September 22, 2025

Re: Pedestrian Level Wind Study Addendum  
601 Laurier Avenue West, Ottawa  
Gradient Wind File 24-134

Gradient Wind Engineering Inc. (Gradient Wind) completed a computational pedestrian level wind (PLW) study to satisfy application submission requirements for the proposed development located at 601 Laurier Avenue West in Ottawa, Ontario<sup>1</sup>. The study was conducted based on architectural drawings of the proposed development provided by Project1 Studio in July 2024<sup>2</sup>.

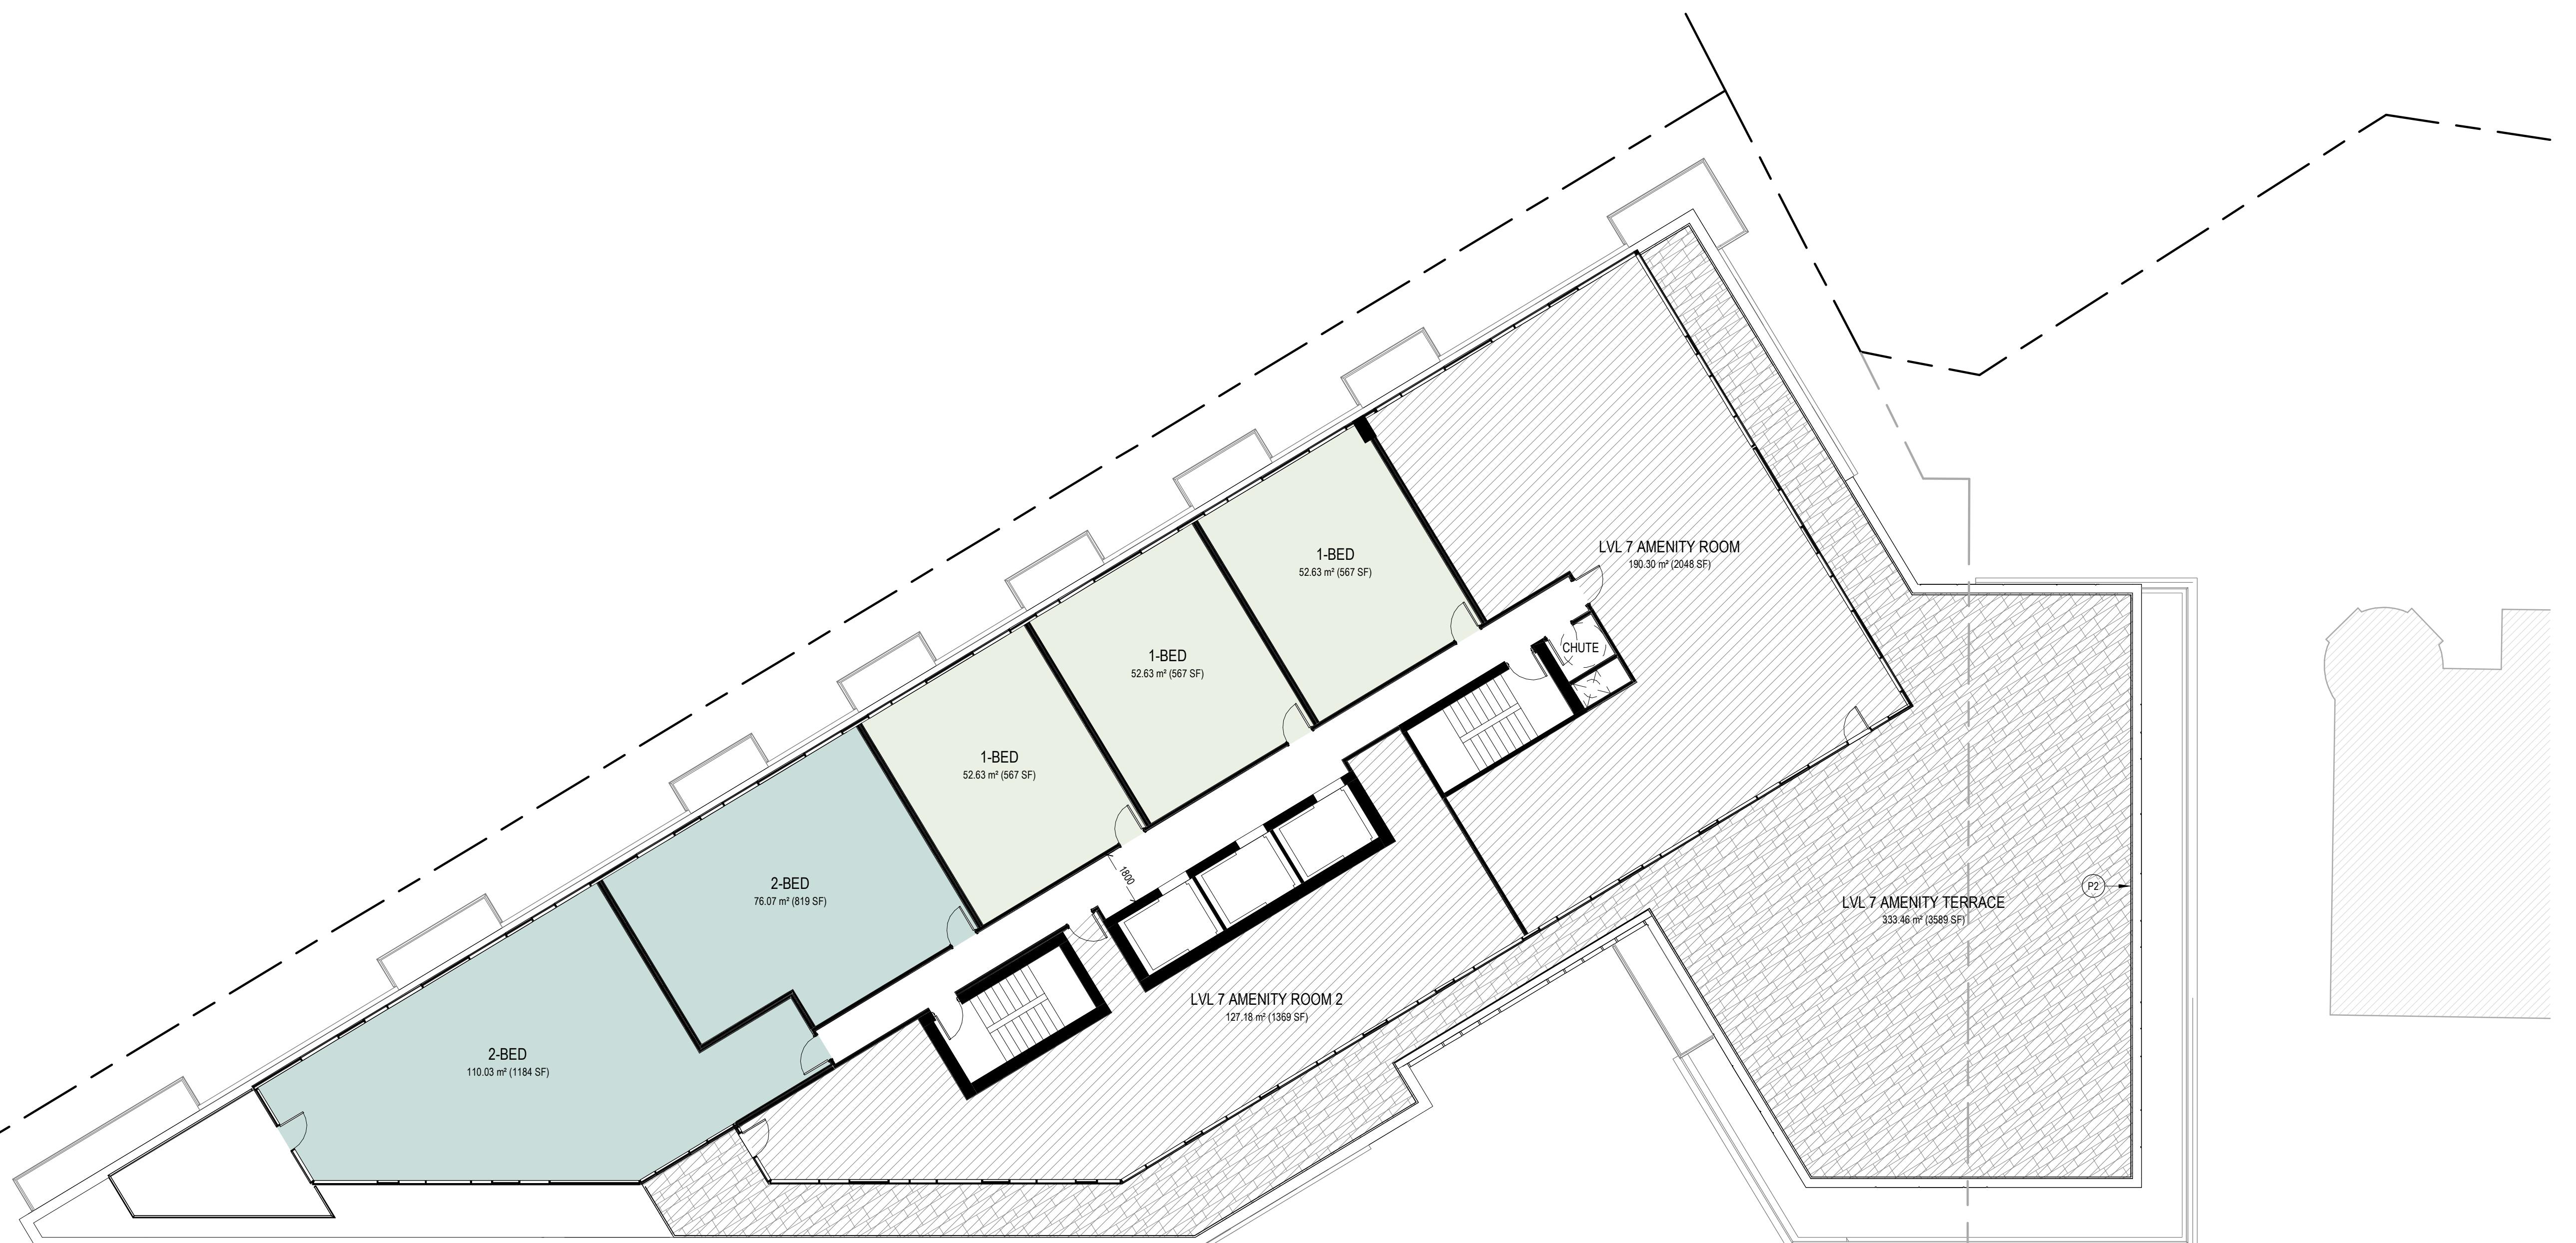
Furthermore, the design team has incorporated the recommended 1.8-m-tall wind screens along the perimeter of the Level 7 terrace and incorporated similar screens along the perimeter of the Level 8 terrace. Conditions within the Level 8 terrace are expected to be suitable for sitting during the typical use period with this screen, which may be considered acceptable.
